# Gardens of Peace Muslim Cemetery

## Written Representation

Deadline 2

1 M25/J28 Cadent Detailed Design 1:500

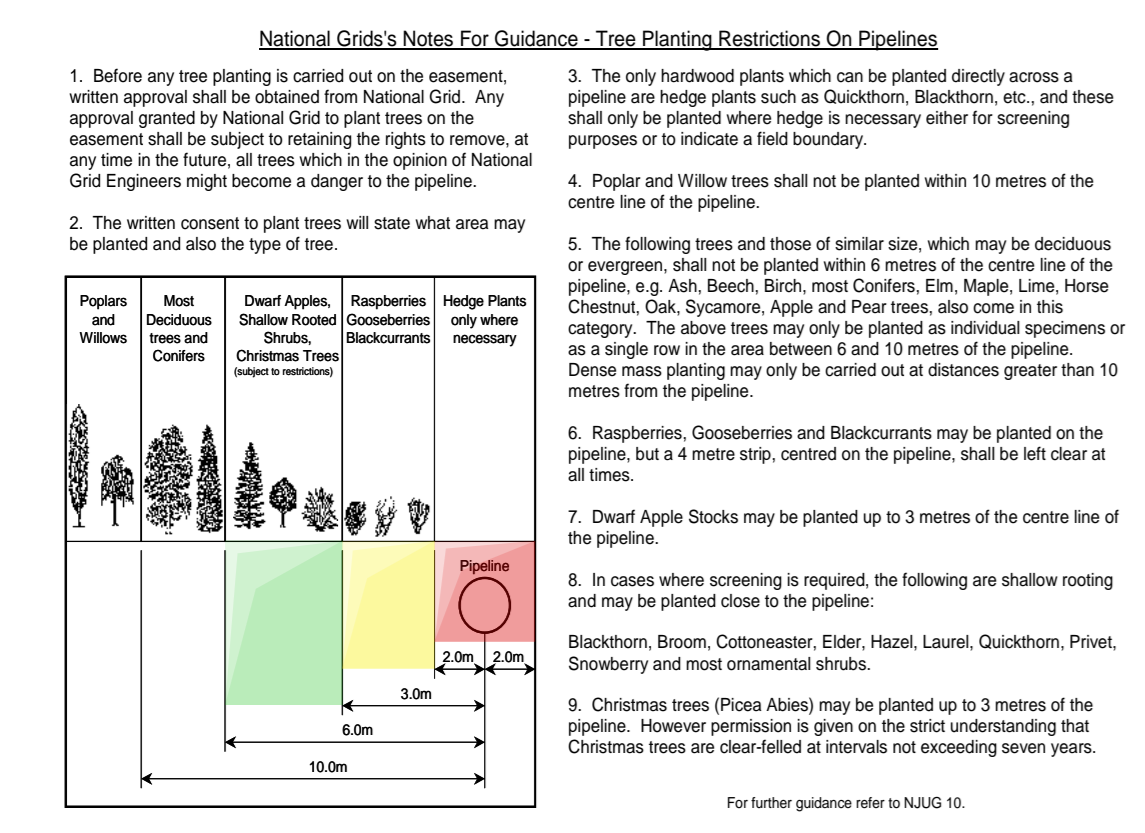
Whilst Cadent has previously advised it would assess the design and construction of a temporary car park to minimise the effect on soil compaction, nothing has been received by Gardens of Peace from Cadent other than suggestion of the use of aluminium tracking for the parking, and as proposed within Appendix 6.

Whilst Gardens of Peace and Cadent have liaised regarding a temporary road, no details have been provided in terms of design and construction by either Cadent or Highways England other than suggestion of use of aluminium tracking for the temporary internal road. This is identified within Appendix 6.

As per the timeline provided in Section 3.1.5, the development of Maylands will have been completed by the time the construction of the proposed Scheme commences. With this, and in light of Plot 1/8 proposals, utilities will need to be relocated (see Appendix 6 – Cadent Detailed Design). These include the existing underground electrical, water and telecoms services to the workshop / store. These were installed in 2020 and are now within the middle of the proposed gas main easement. Other services will include the drainage pipes under the internal road and associated manholes and chambers and underground lighting cables.

#### 9.59 Overlay plan of Plot 1/8 and the burial plots

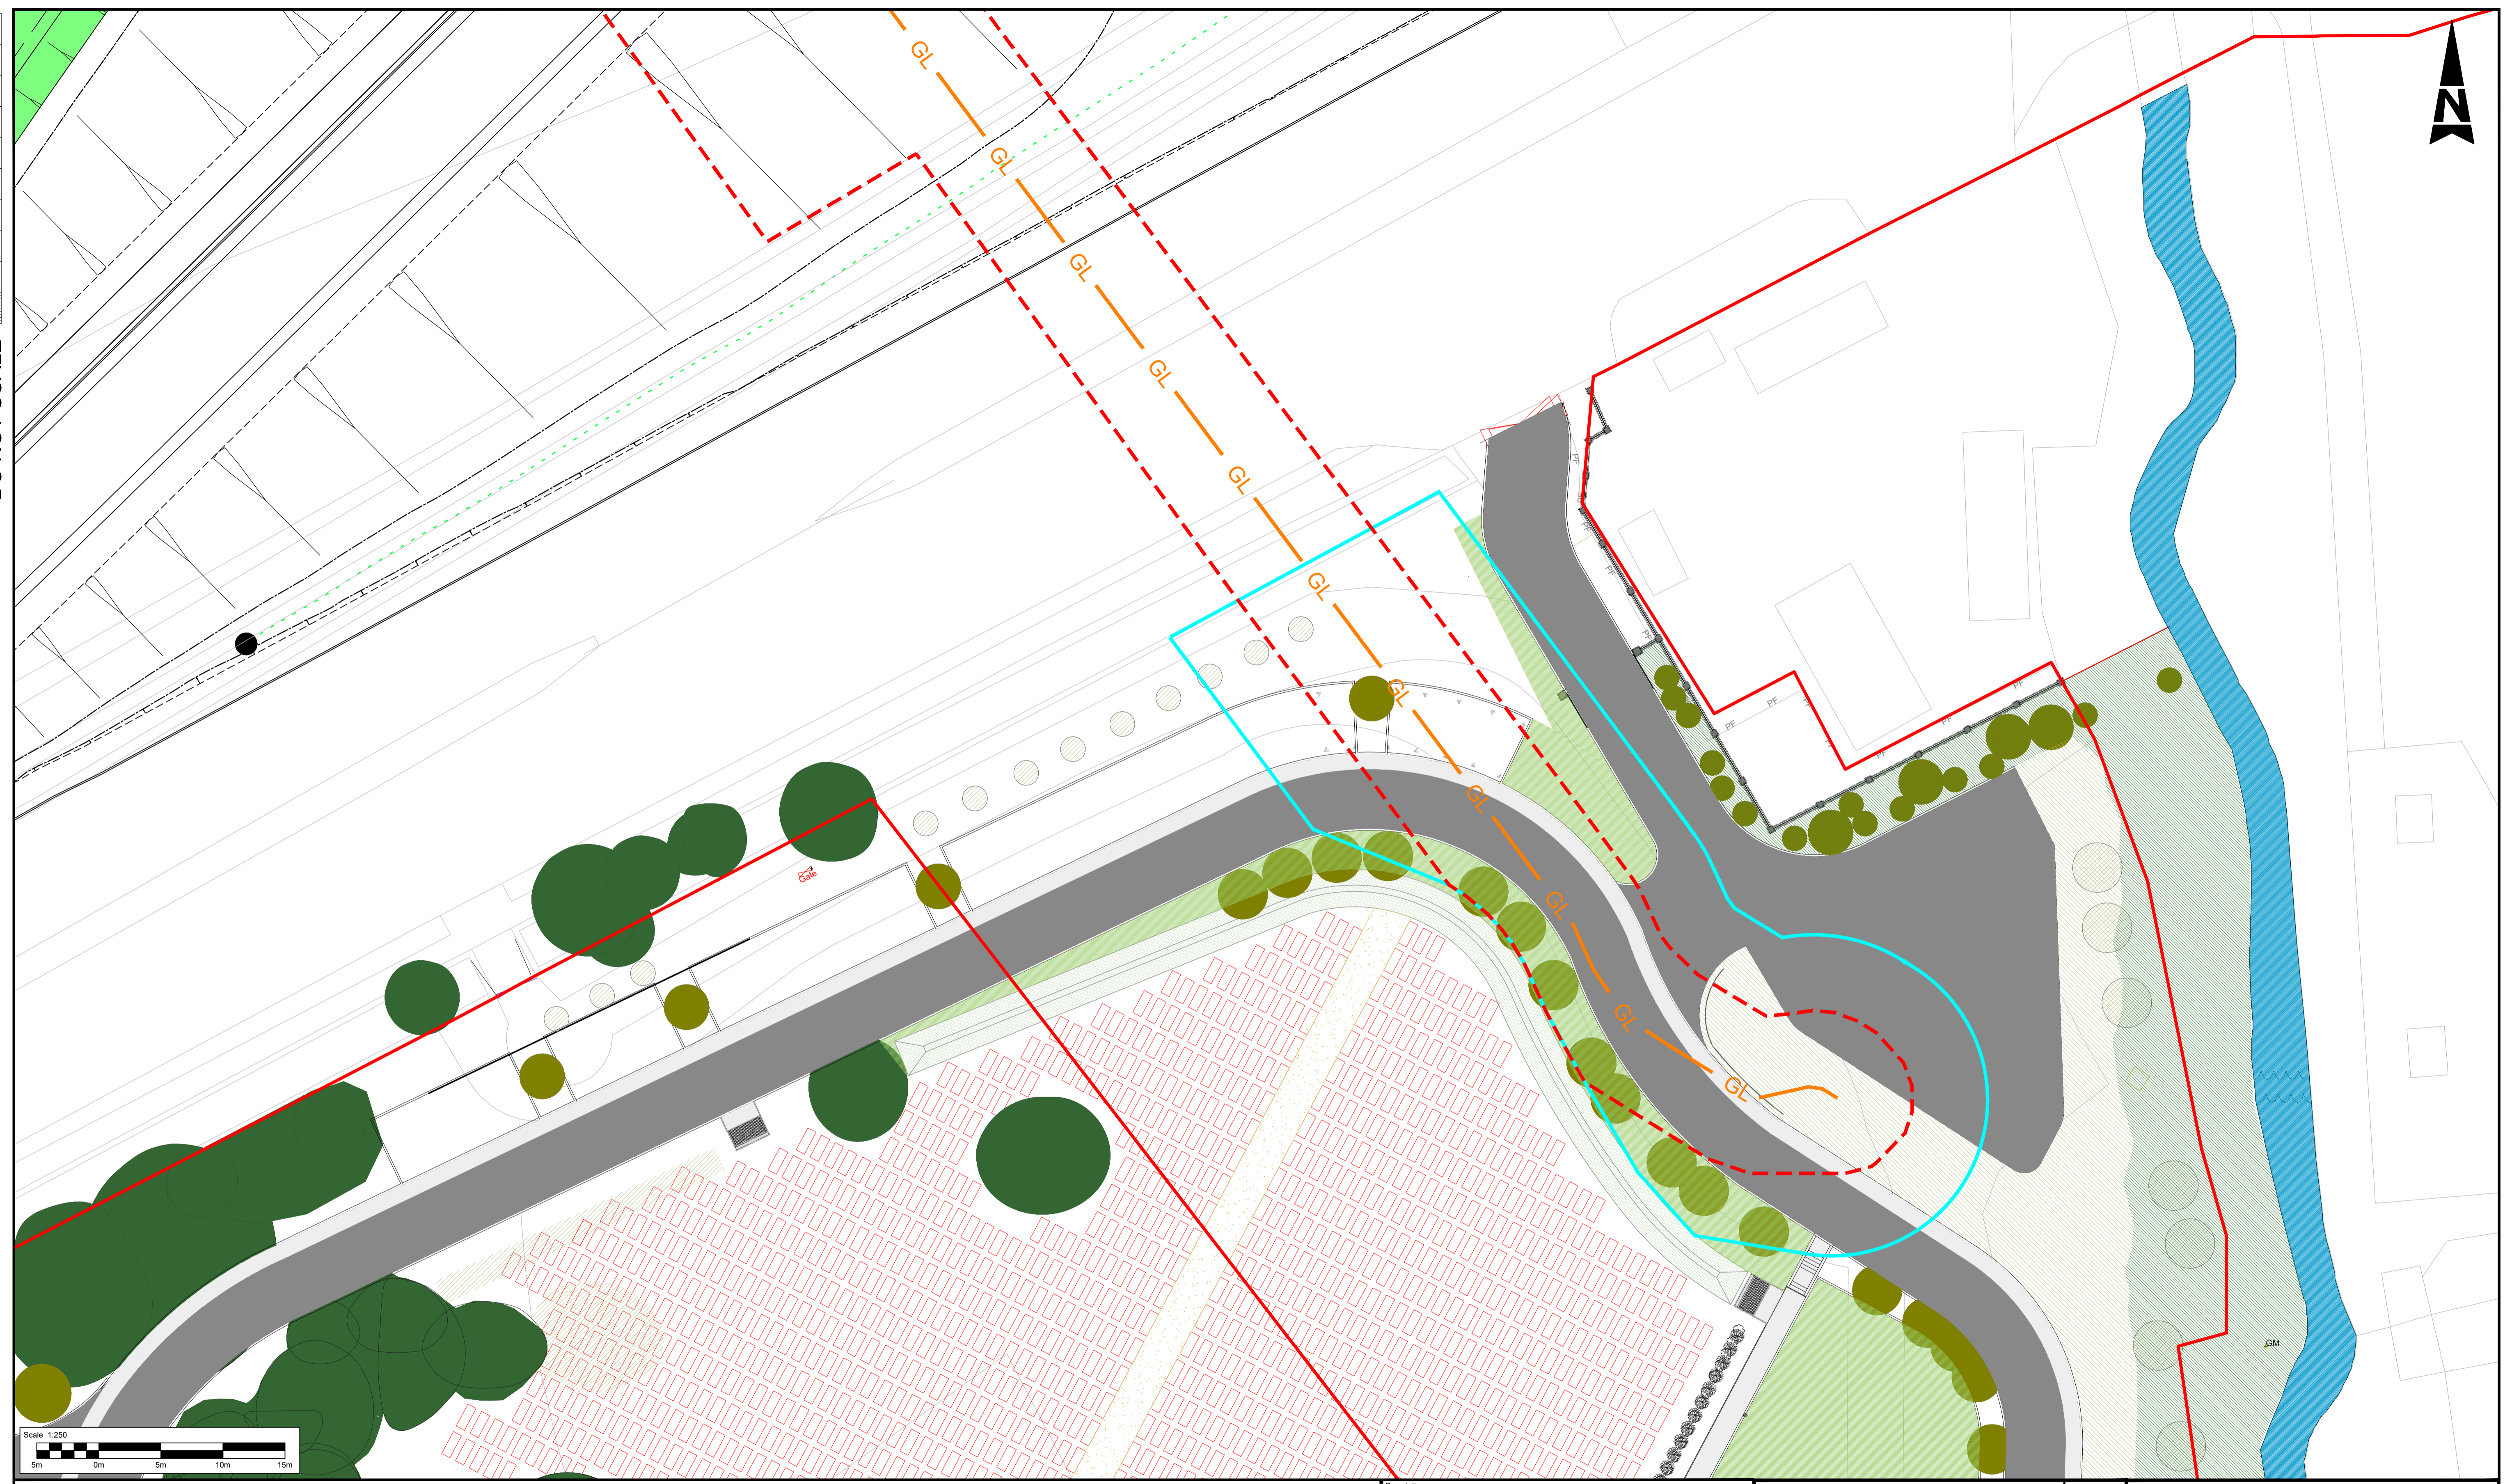
- a. Temporary loss of internal road network (as evident within appendix 4)
- b. Temporary closure of service entrance (off Colchester Road into Maylands) (as evident within appendix 4)
- c. Temporary loss of half of the cemetery's overflow car park (shaded light green in Appendix 4)
- d. Temporary loss of the soil storage area (as evident within appendix 4)
- e. Temporary loss of access to maintenance building and store
- f. Permanent loss of 512 burial plots (as evident within appendix 4)

Taking into account the intended nature of the land, and in light of the whole plot being subject to the acquisition of permanent rights, it has to be assumed that all the land will be sterilised from its intended use, which directly affects 512 burial plots. This brings rise to significant concerns, not just to the financial viability of the cemetery, but the inability to meet the requirements of the Muslim community.
